Consultation Response from KC, Conservation and Design		
2020/90989 14, Edgerton Road, Edgerton, Huddersfield, HD1 5RB		
Erection of single storey extensions and rear dormer and alterations (within a Conservation Area)		
Date Responded: 08/07/20	Responding Officer: Craig McHugh	Responding Ref: Edgerton
Significance of the heritage assets affected No.14 Edgerton Road dates from c.1851 and was built as an investment for Benjamin Casson, who was high bailiff at Huddersfield County Court. Its design takes its inspiration from the 16th century, when English architecture was influenced by both French and Flemish styles and existing English traditions. The result was a composite and richly decorated style. It makes a positive contribution to the character and appearance of the Edgerton Conservation Area. The particularly fine group of Victorian and later villas set in spacious grounds on Edgerton Road illustrate the affluence and taste of Huddersfield's middle-classes in the late nineteenth and early twentieth centuries. Relevant Policies/Guidance Section 72(1) of the Planning (Listed Buildings and Conservation Areas) Act 1990 requires that the Local Planning Authority shall pay special a

CLIENT DETAILS 14 EDGERTON ROAD HUDDERSFIELD	DRAWING No 2019045(0-01)	REVISION
DRAWING INFO EXISTING PLANS	SCALE 1:50	DATE 08/11/19
		DRAWN BY JH

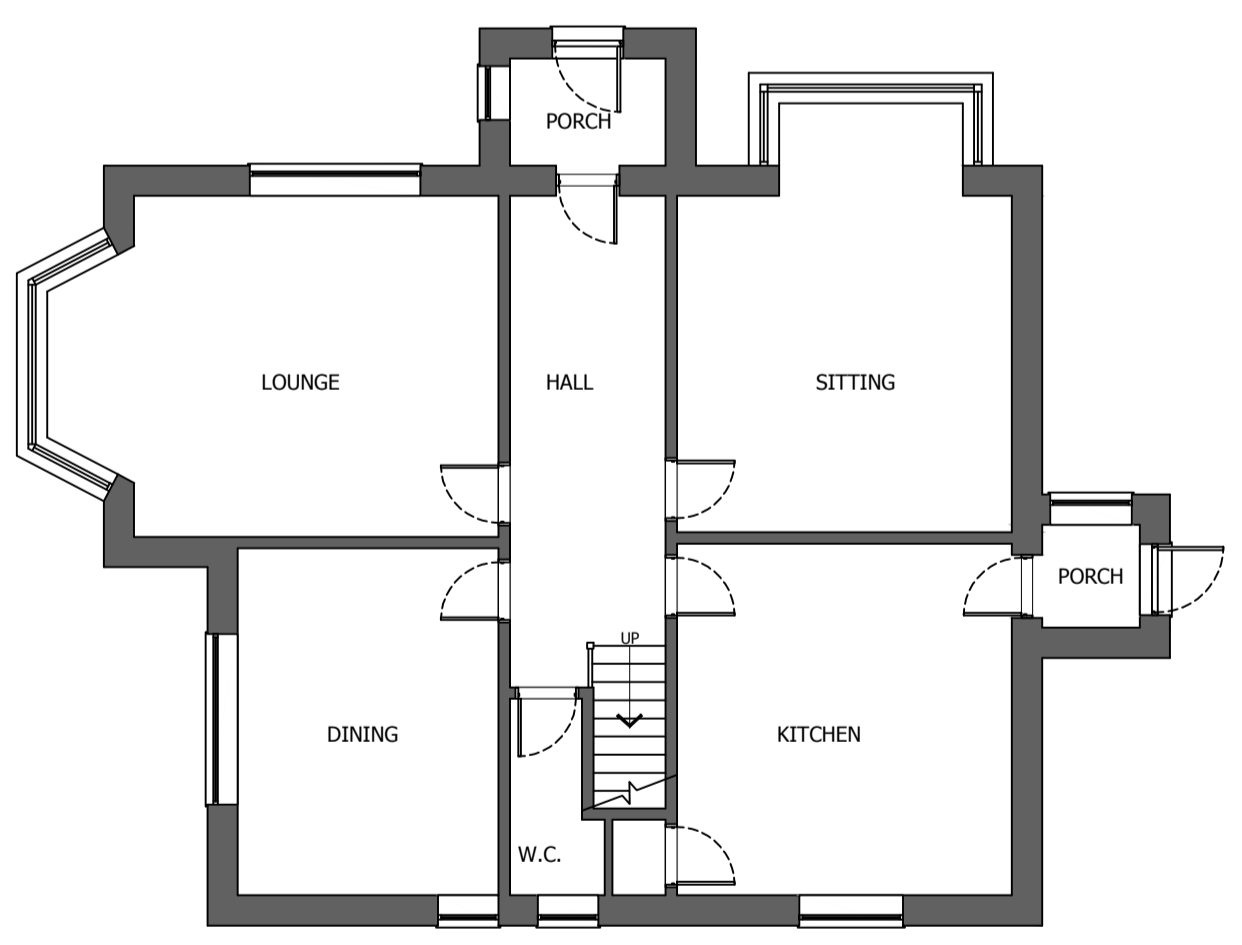
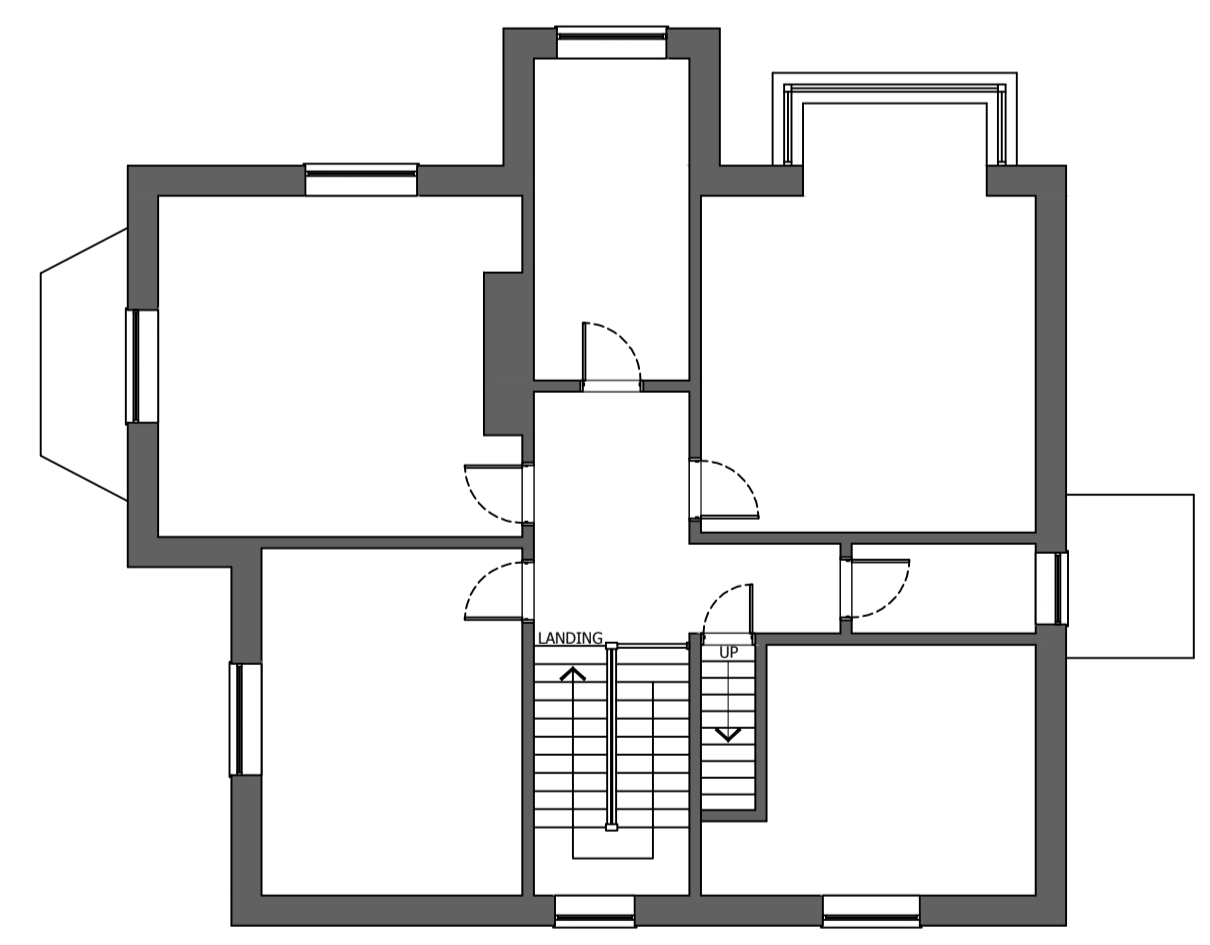
To the rear the glass balcony at ground floor would be out of keeping with the existing building, as would the flat roofed dormer. A traditional pitched roof dormer would be acceptable. The existing and proposed drawings appear to show that the long staircase window is to be moved, this may be a drawing error as the floor plans indicate otherwise.

CLIENT DETAILS 14 EDGERTON ROAD HUDDERSFIELD	DRAWING No 2019045(0-)-02		REVISION
	DRAWING INFO PROPOSED PLANS	SCALE 1: 50	DATE 08/11/19
			DRAWN BY JH

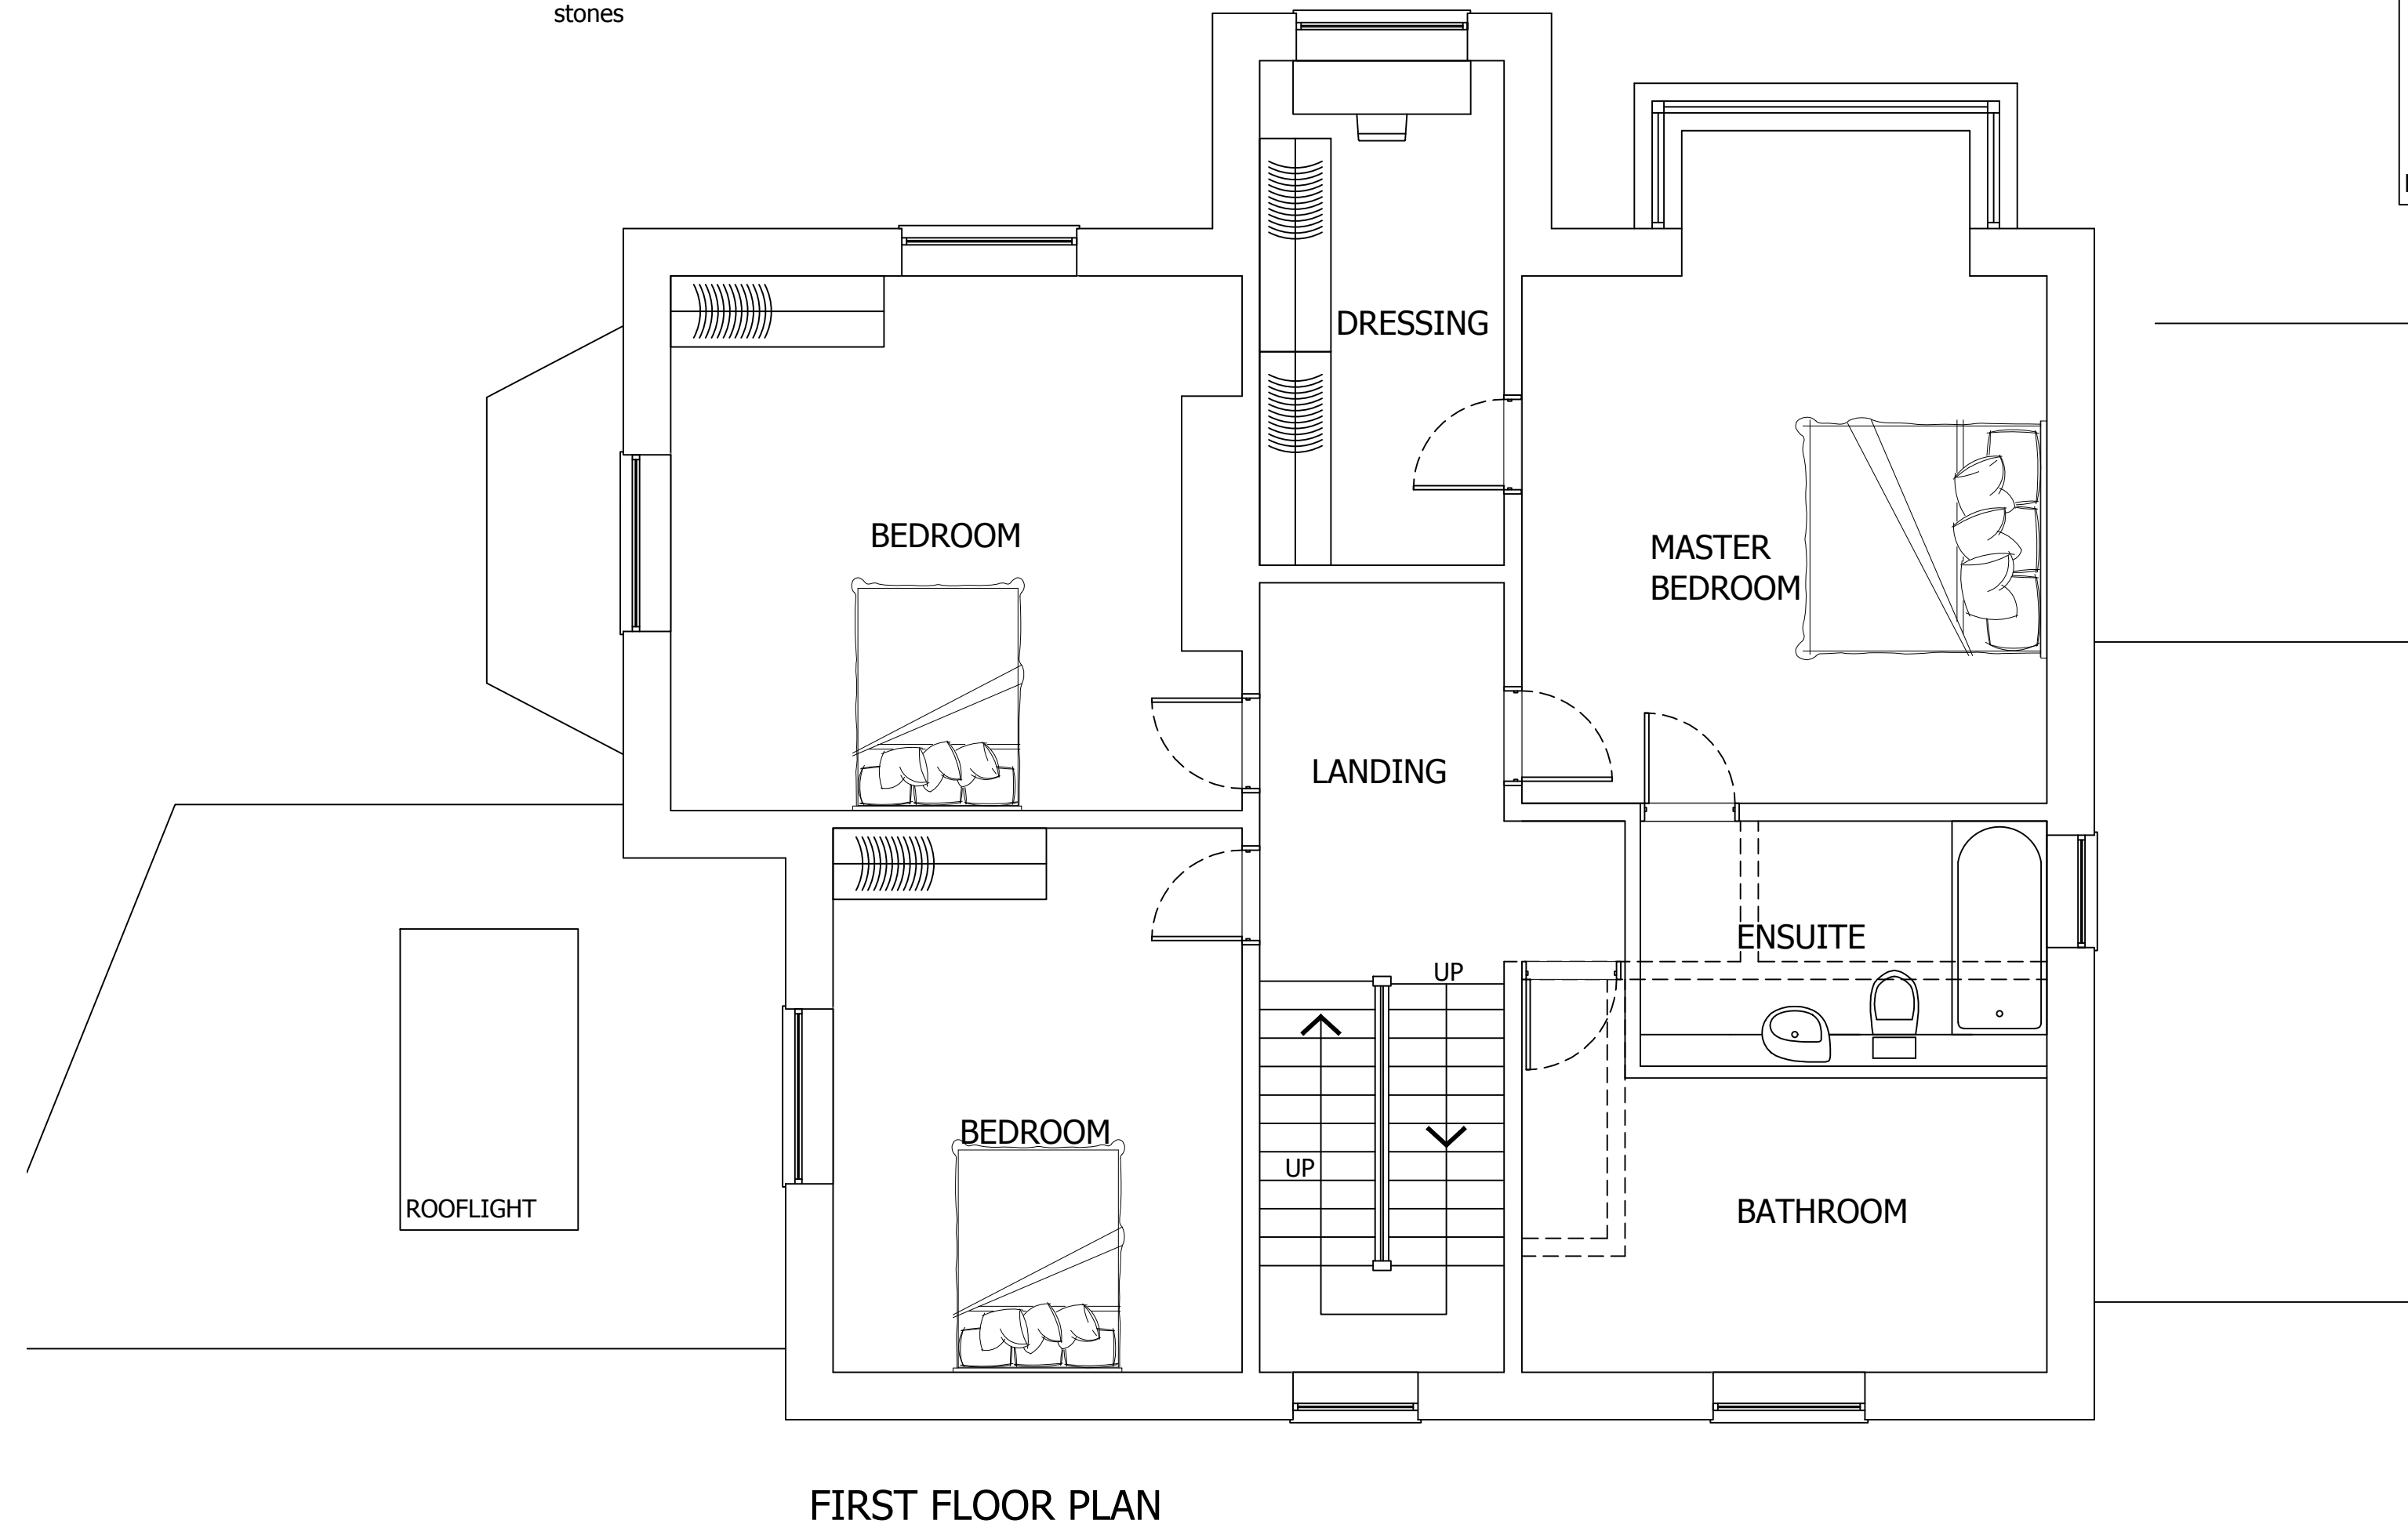
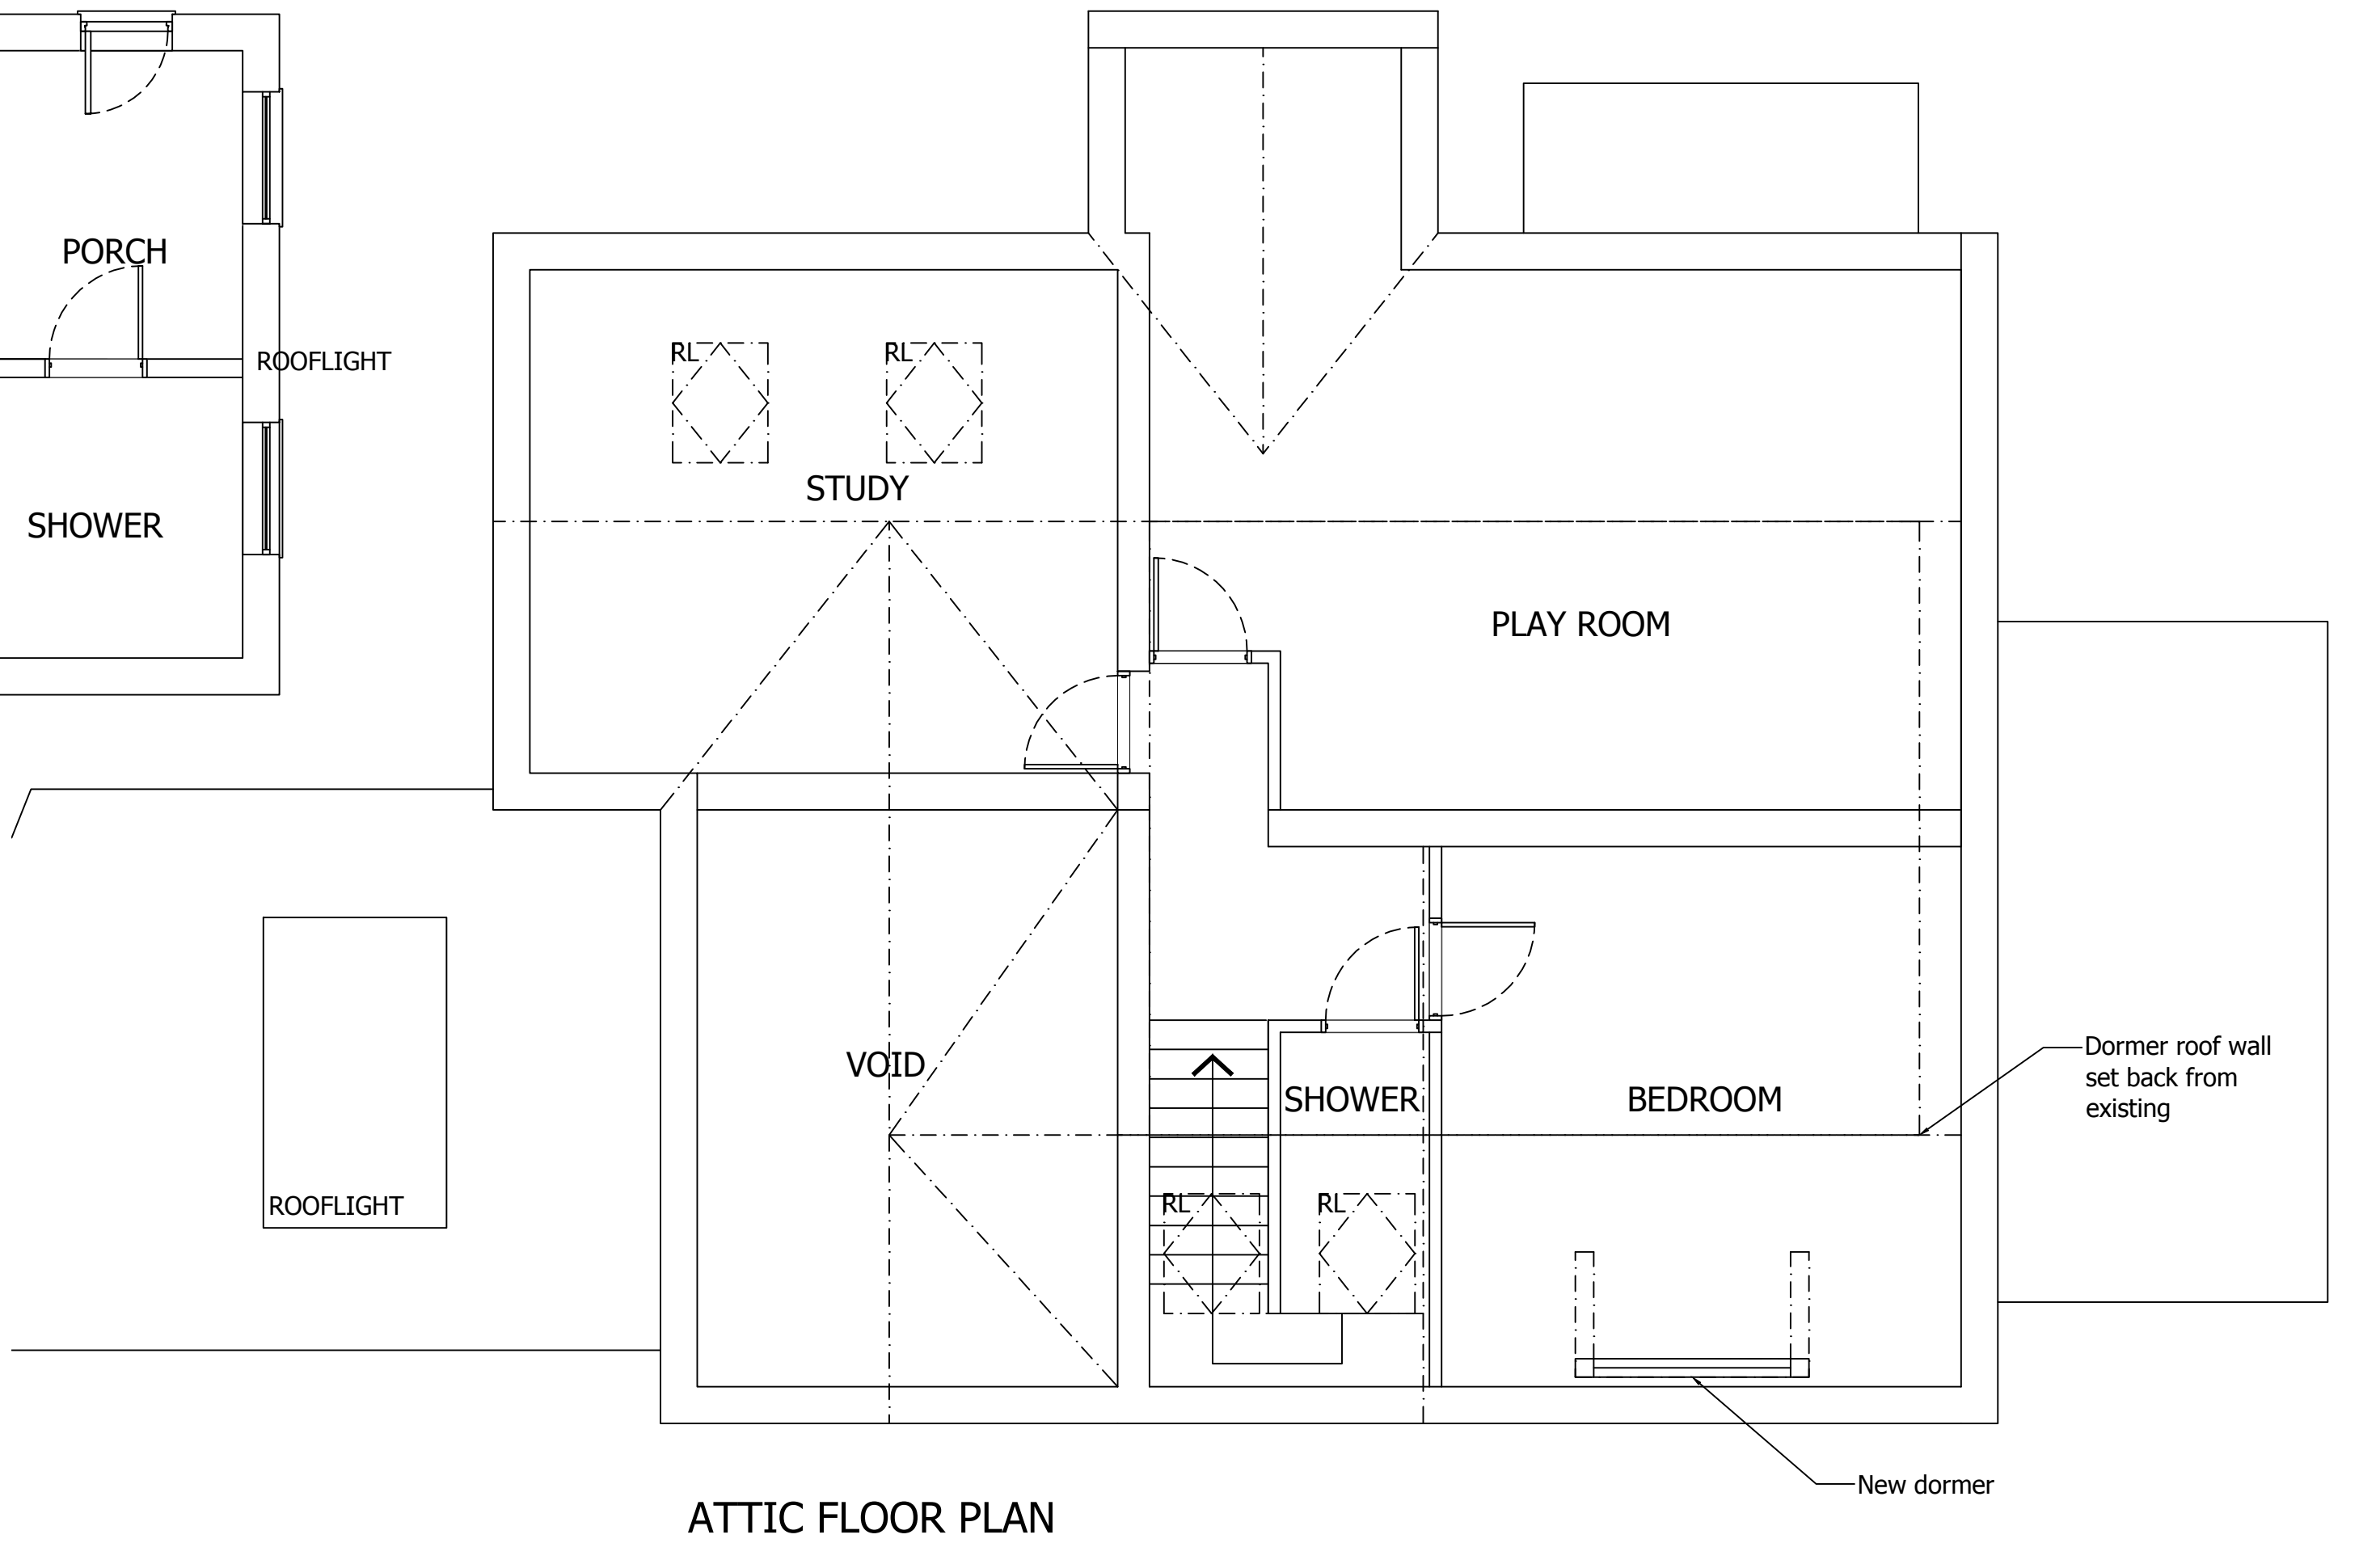
basement level and an unbroken wall above. In summary this extension does not relate to the scale, materials or details of the original building.

The existing extension to the west elevation does not respond to the character of the existing building. The proposed extension would compound that impact. The externally expressed chimney stacks should not be built across, the canopy and window proportions do not relate to the existing building. The need for a further entrance has to be questioned, could shower facilities not be located near a basement door at the rear of the building if needed?

The need for the flat-roofed dormer spanning the double pile roof should be questioned, it is not evident how these spaces are accessed at present. Maintenance could be improved by the additional of rooflights providing for inspection and access to the valley gutter.
